Application for a Non-Material Amendment Following a Grant of Planning Permission

Retention of existing residential annexe, conversion of part of existing garaging to extend annexe, replacement of existing roof, including the addition of solar panels, adjustments to existing fenestration and application of external cladding, and associated works

DC/22/06217

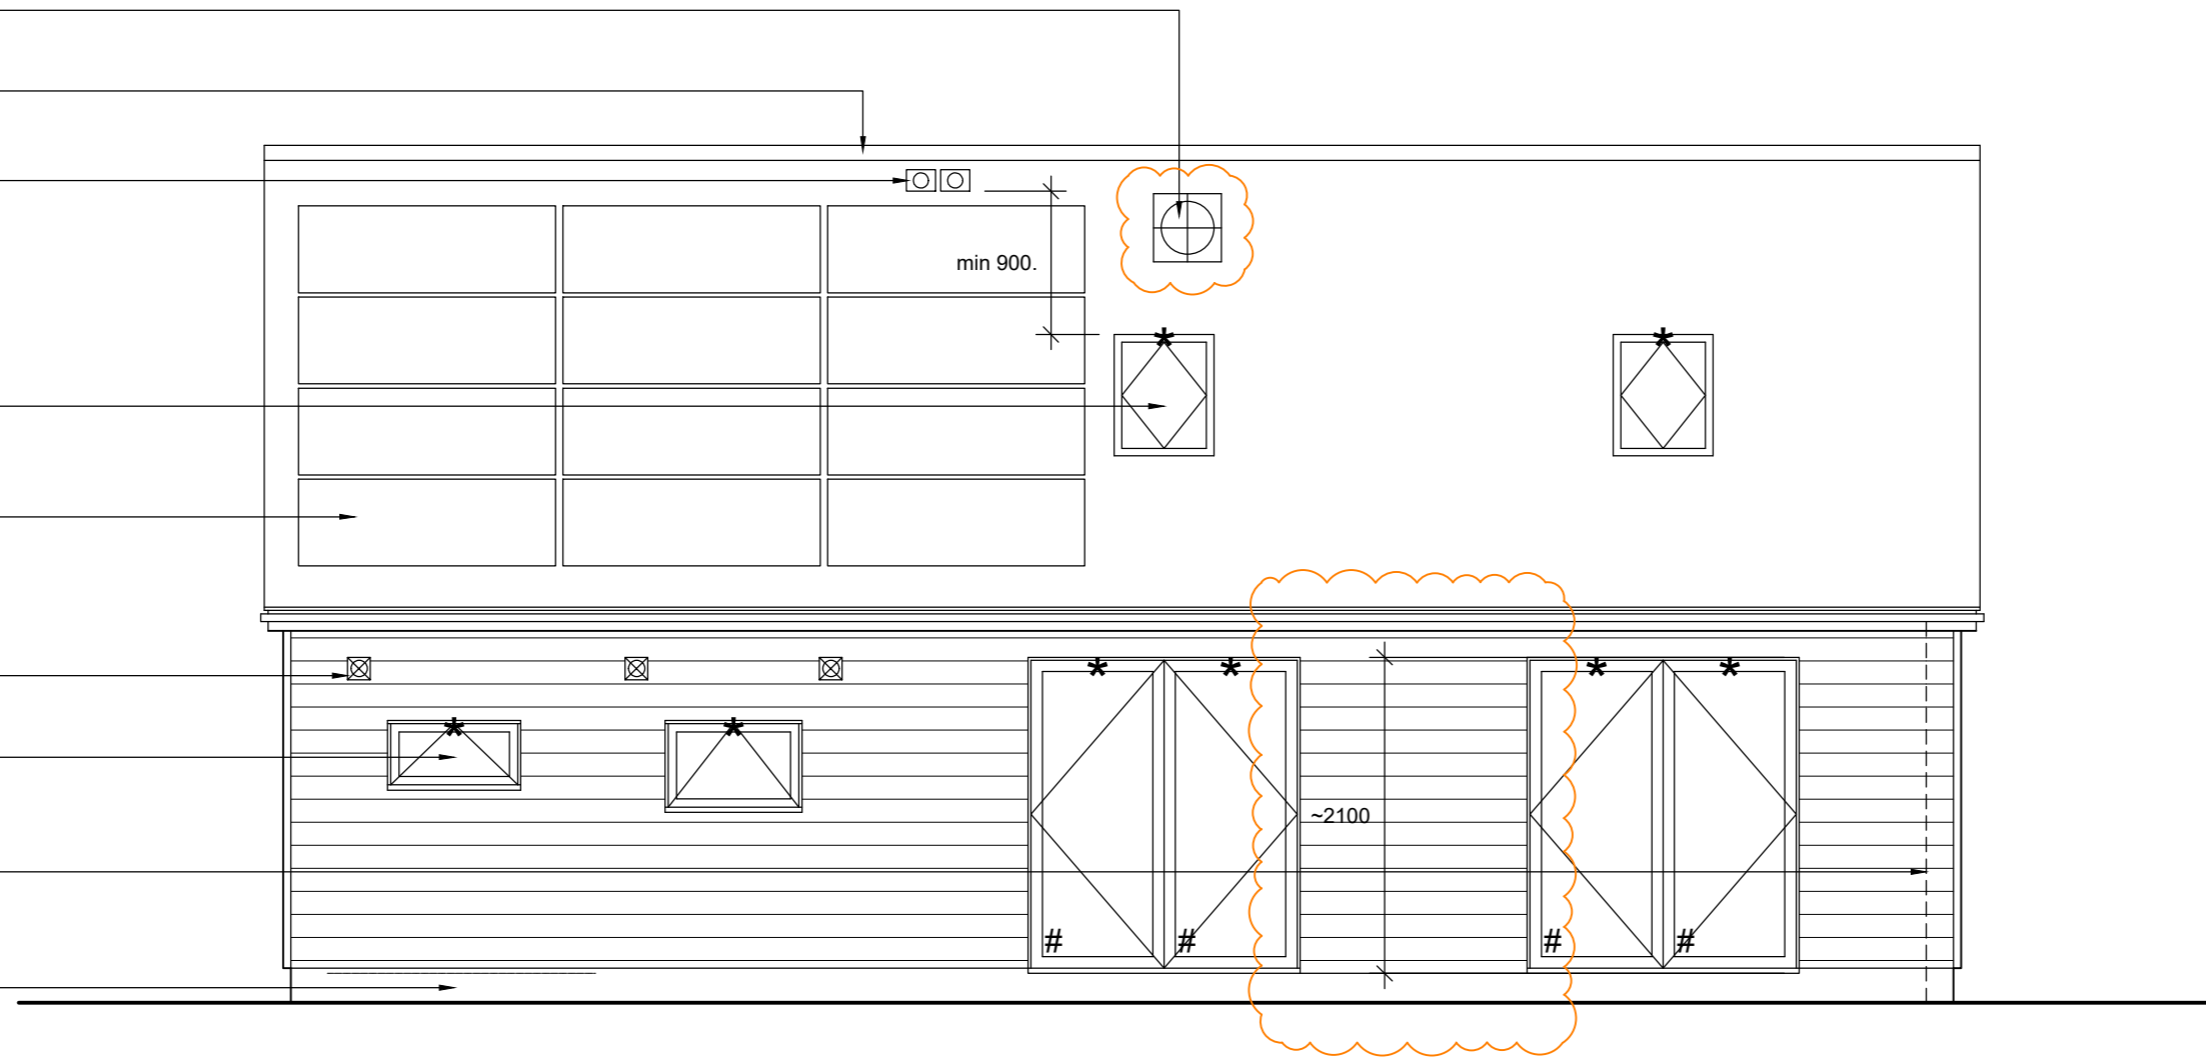
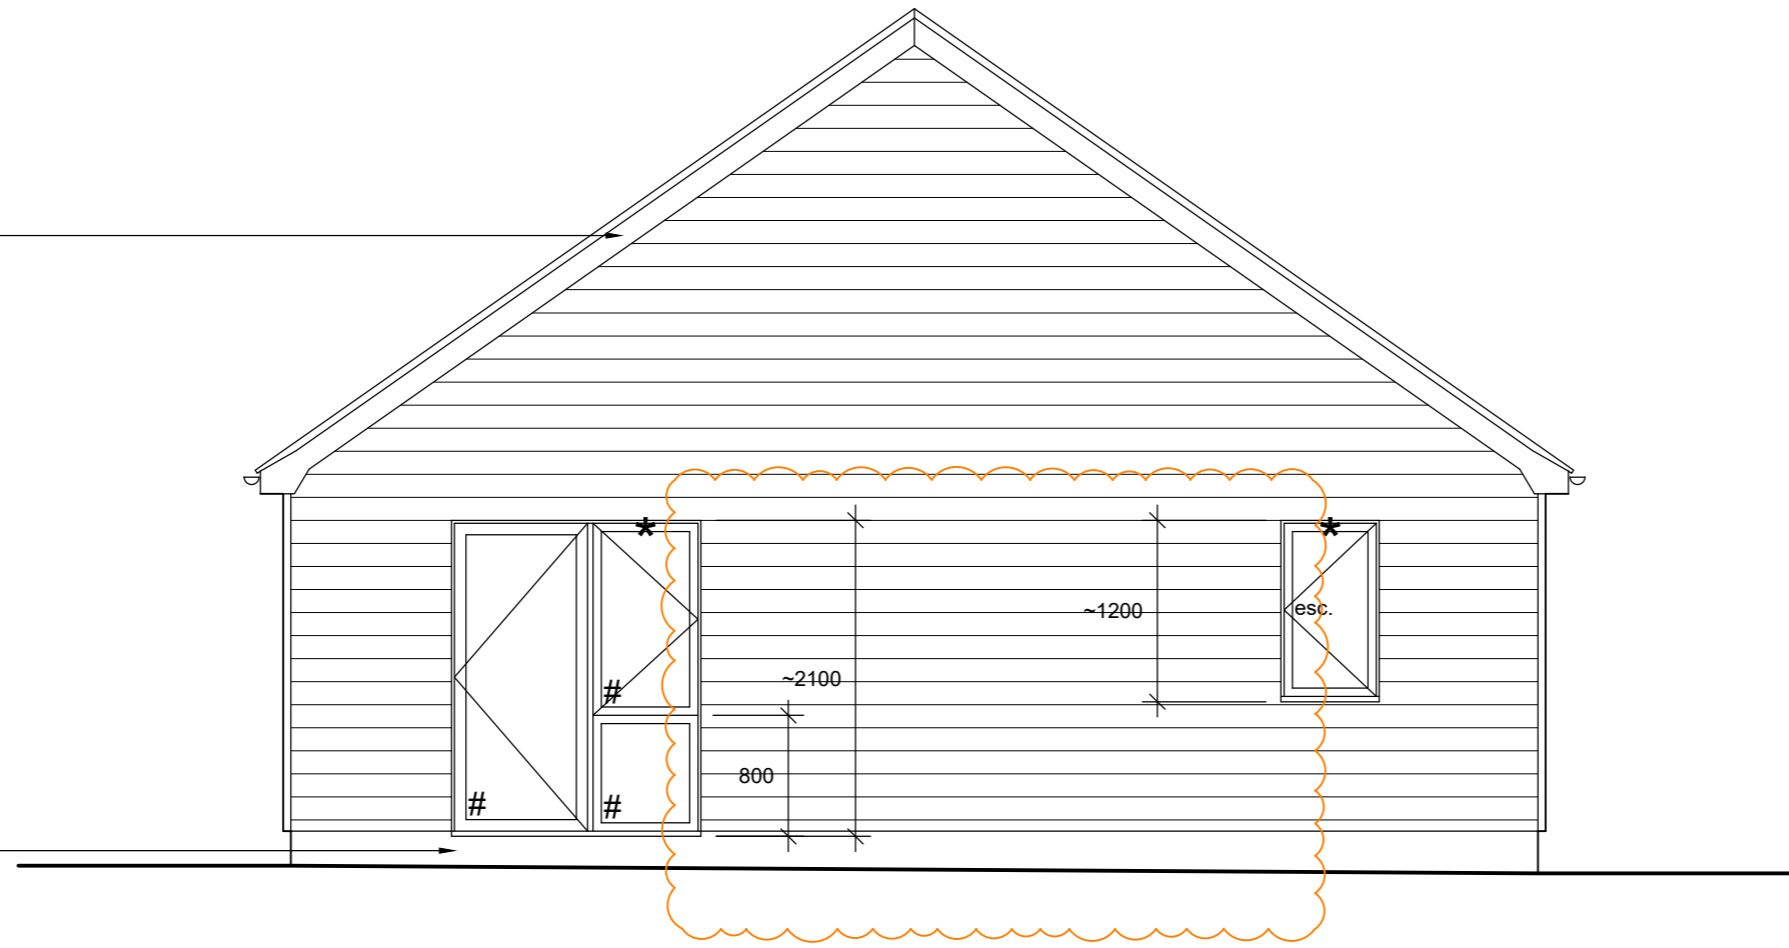
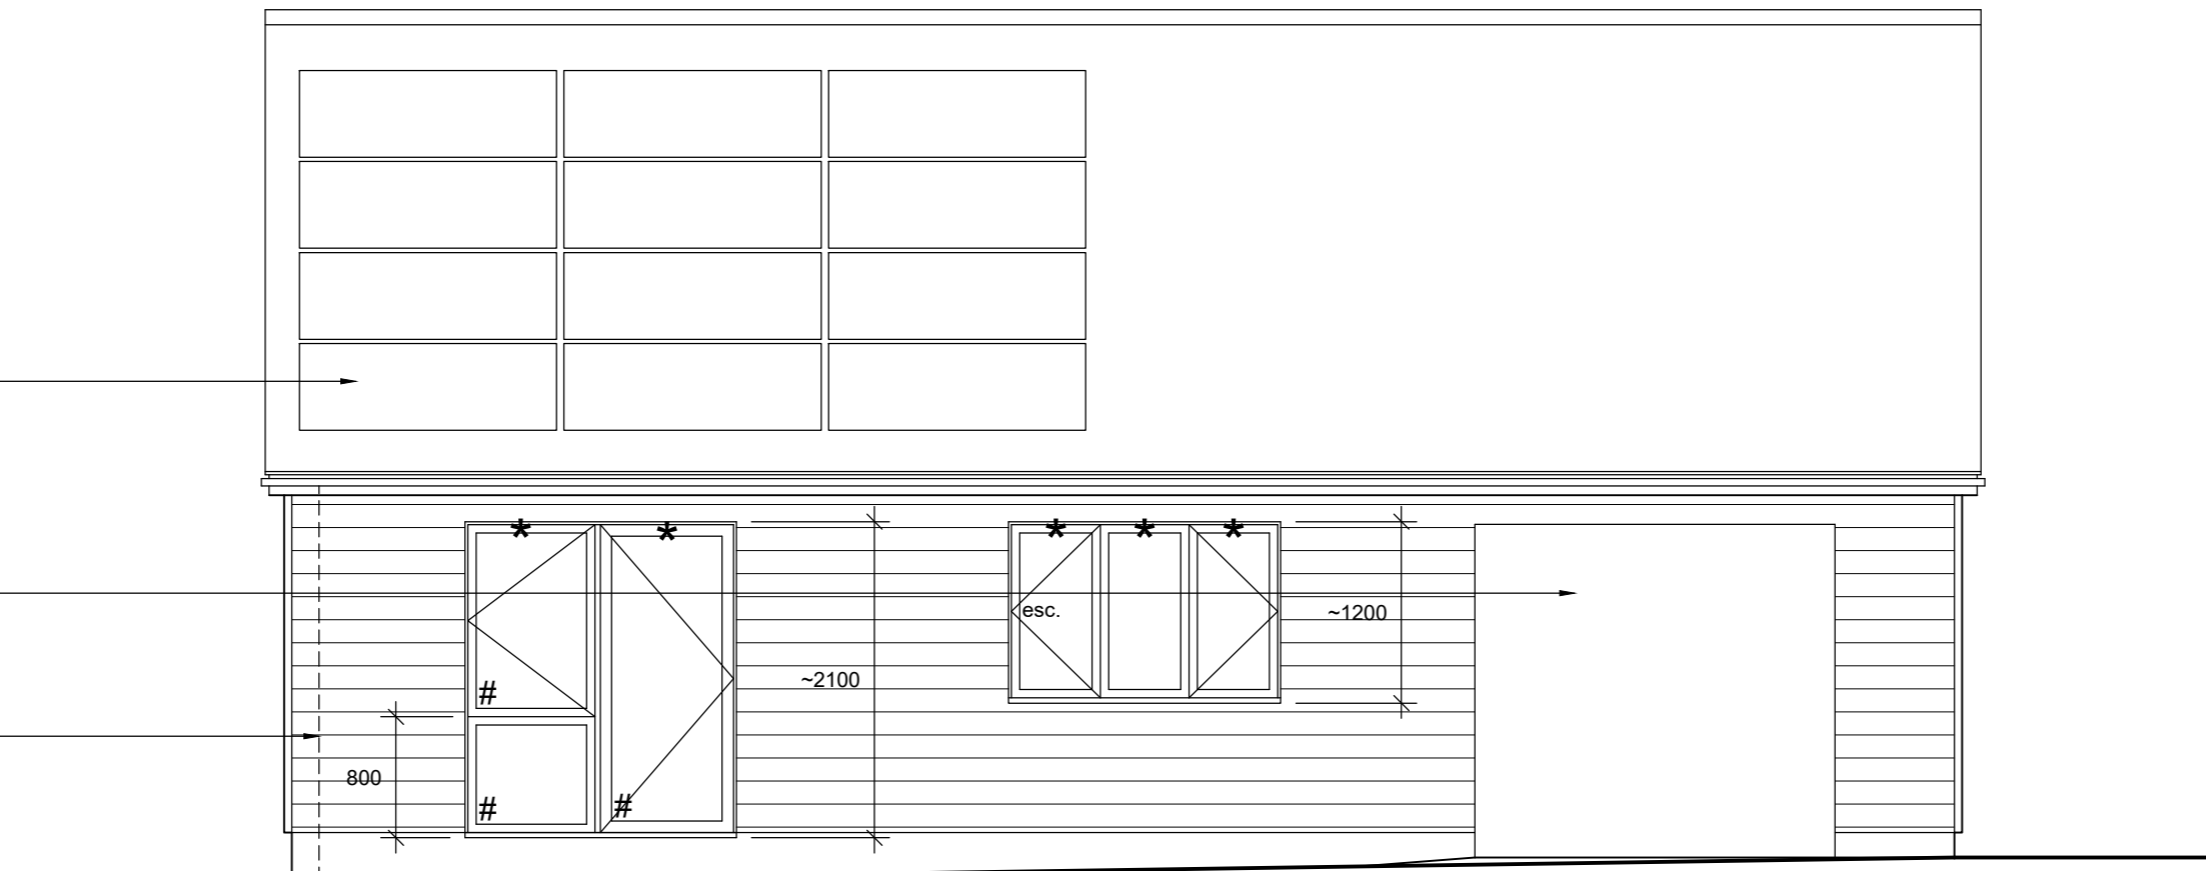
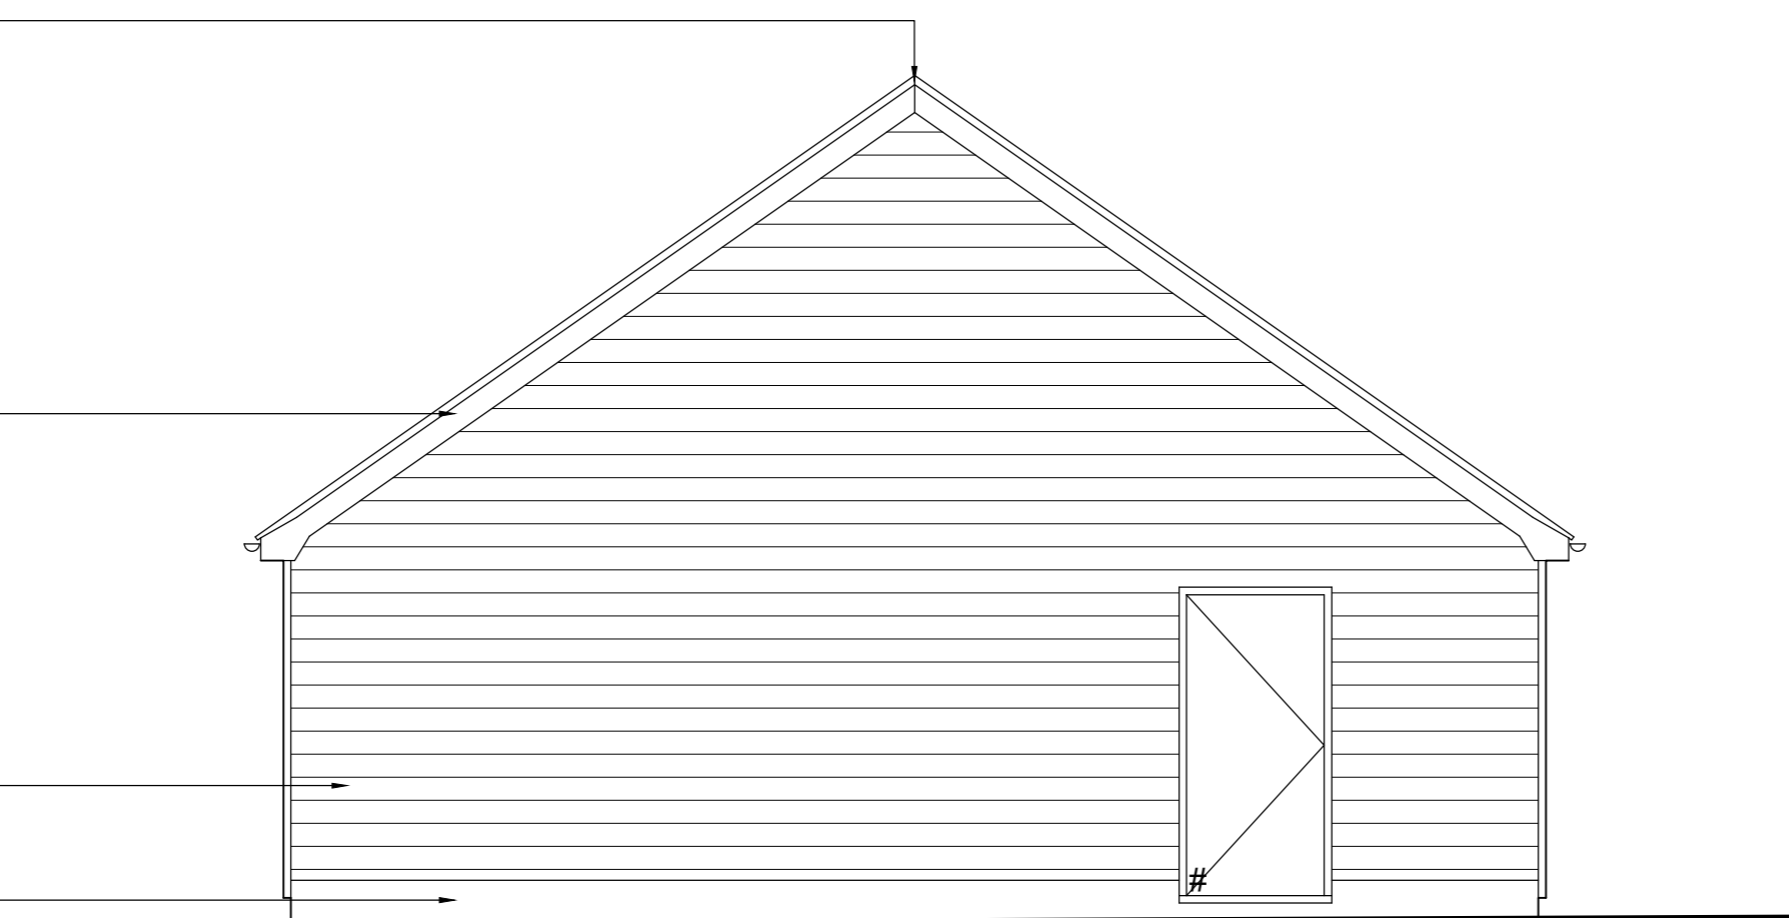
- Omission of woodburner and flue
- Installation of new sun tunnel to internal shower room, with external frame of the rear roof slope
- Omission of brick panels from south and west elevations
- Inclusion of aluminium / upvc windows & doors (as existing) in lieu of timber

To improve air quality, to provide light to proposed internal shower room, to improve aesthetics (brick panel in vicinity of flue no longer needed to resist heat, so timber cladding proposed throughout), for cost and maintenance purposes and to reflect the existing materials.
